Harnett County
108 EAST FRONT STREET
LILLINGTON, NC 27546
Phone:
Fax:

SUBJECT: BRES1910-0047
BUILDING RESIDENTIAL

Here are the results of all Inspections located at **147 E MAIN ST:**

DECK LAYOUT

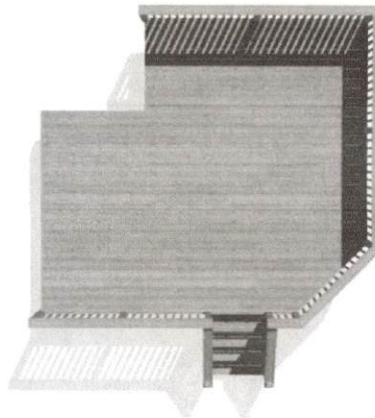
Inspection Type: FINAL**
Scheduled Date/Time: 11/19/2019
Completed Date/Time: 11/19/2019
Inspector: Steven Gazlay
Result: DISAPPROVED
Remarks:
Notes: Inspector RLH changed the inspection assignment from RLH to SPG
Handrails must be between 34" and 38" to top of handrail. Must use 2x4 for hand grip portion.
